**WELWYN HATFIELD BOROUGH COUNCIL
EXECUTIVE DIRECTOR - PLANNING, PUBLIC PROTECTION AND GOVERNANCE**

Application No: 6/2020/2180/LAWP
Location: 9 Hook Lane Northaw Potters Bar EN6 4DA
Proposal: Certificate of lawfulness for installation of 1x side dormer to facilitate loft conversion
Officer: Mr Tom Gabriel

Recommendation: Refused

DRAWING TITLE  
Location Plan, Block Plan, Proposed Drawings

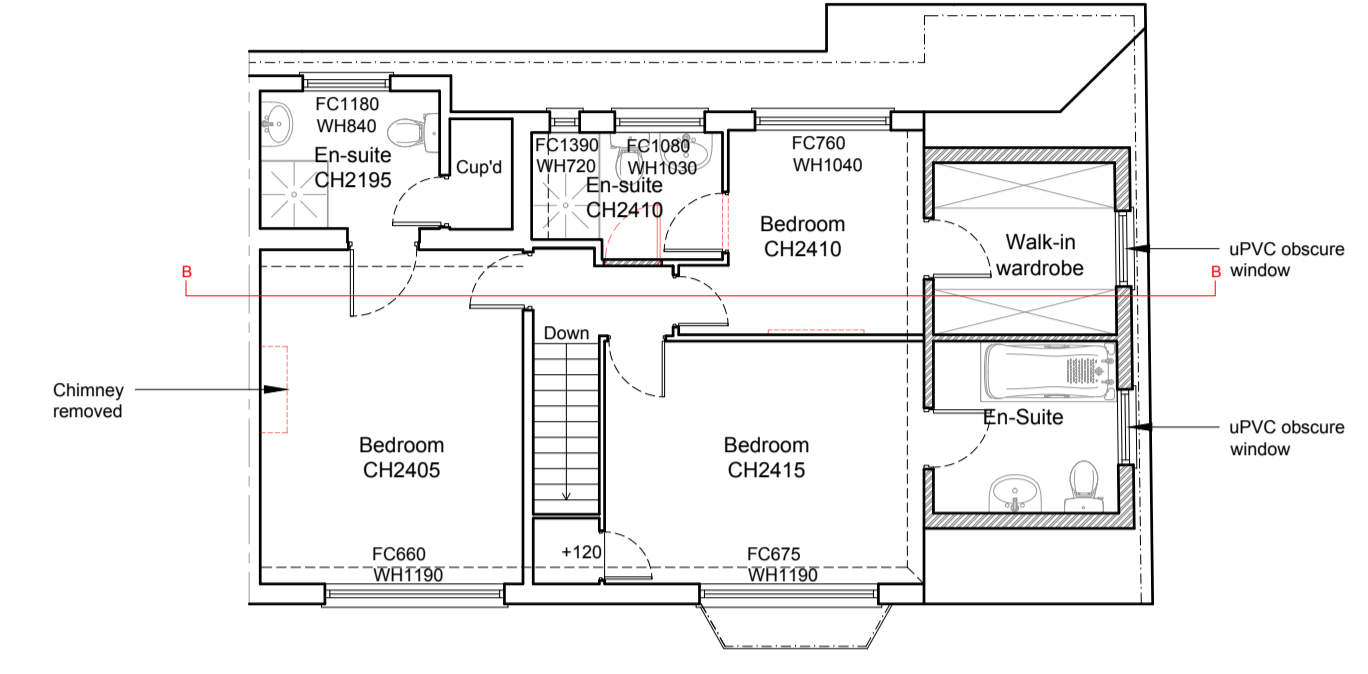
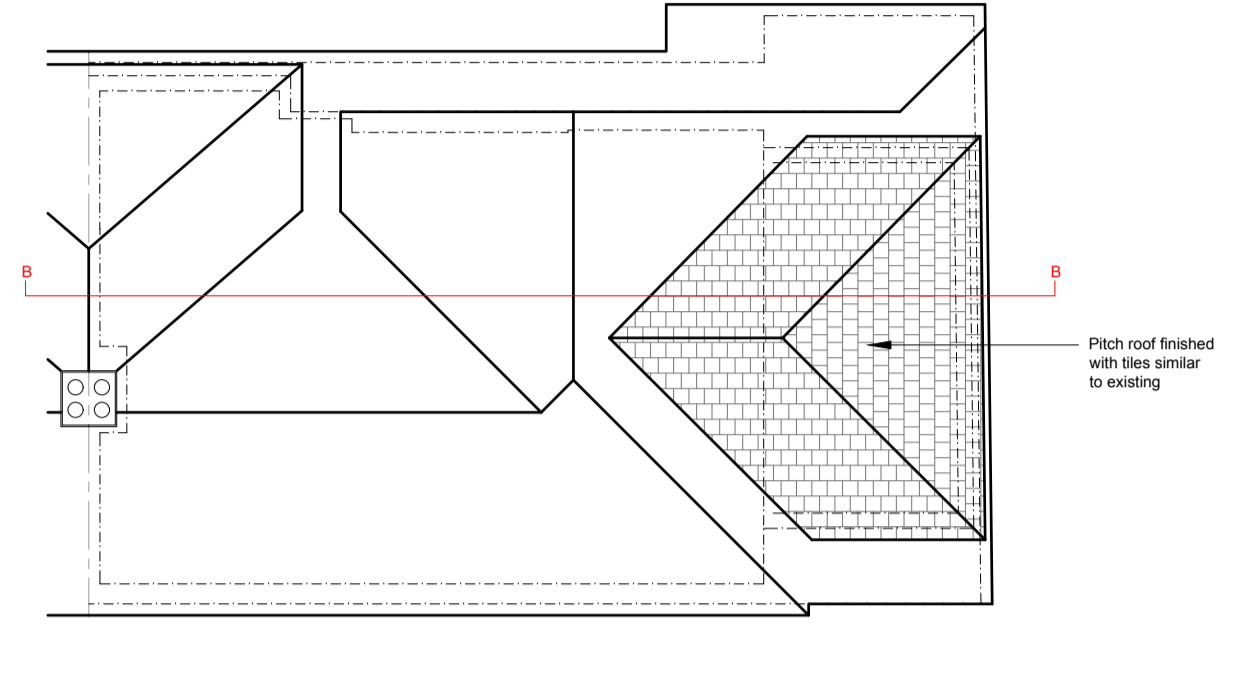
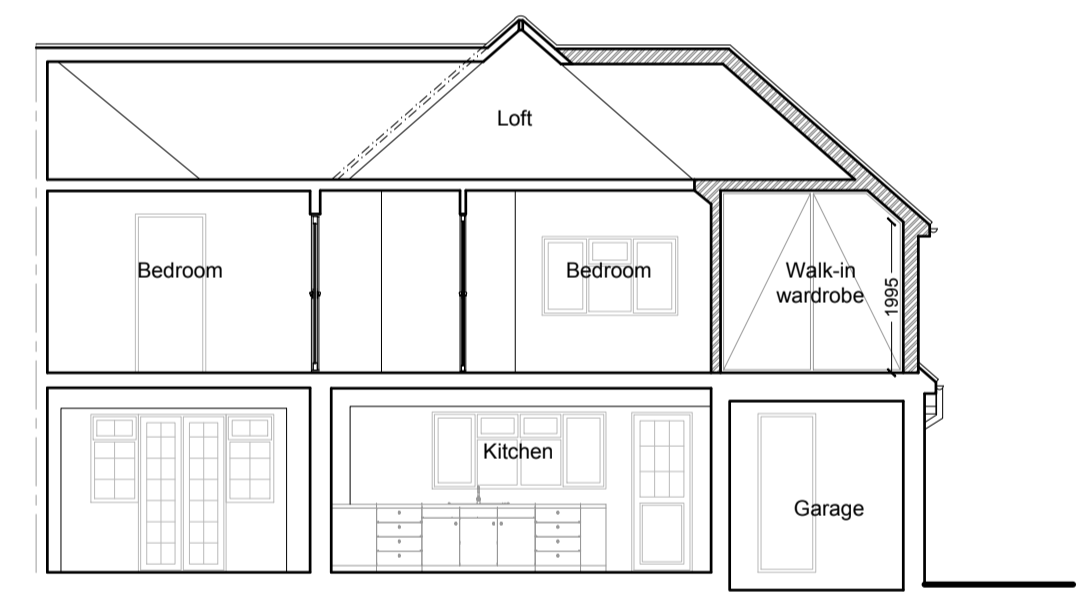
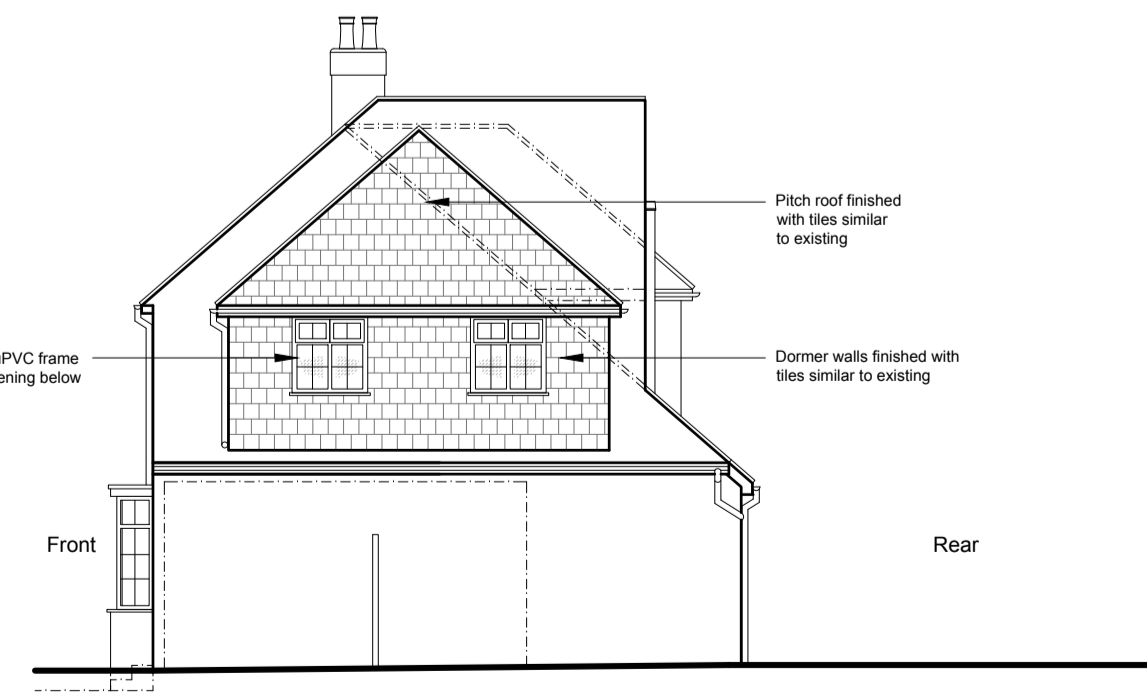
Notwithstanding the above calculations and considerations, the proposed side dormer window would be partially sited above and be attached to the single storey side/ rear extension granted under ref. S6/1988/0172/FP. Accordingly, in their totality, the proposed additions to the dwelling would represent a wraparound extension. This may not be classed as permitted development under Class A i, A j (i), (ii) and (iii), A j (a) and A k (iv) of the Town and Country Planning (General Permitted Development) Order 2015 (as amended).

1. The proposed side dormer window would be partially sited above and be attached to the single storey side/ rear extension granted under ref. S6/1988/0172/FP. Accordingly, in their totality, the proposed additions to the dwelling would represent a wraparound extension. This may not be classed as permitted development under Class A i, A j (i), (ii) and (iii), A j (a) and A k (iv) of the Town and Country Planning (General Permitted Development) (England) Order 2015 as amended.
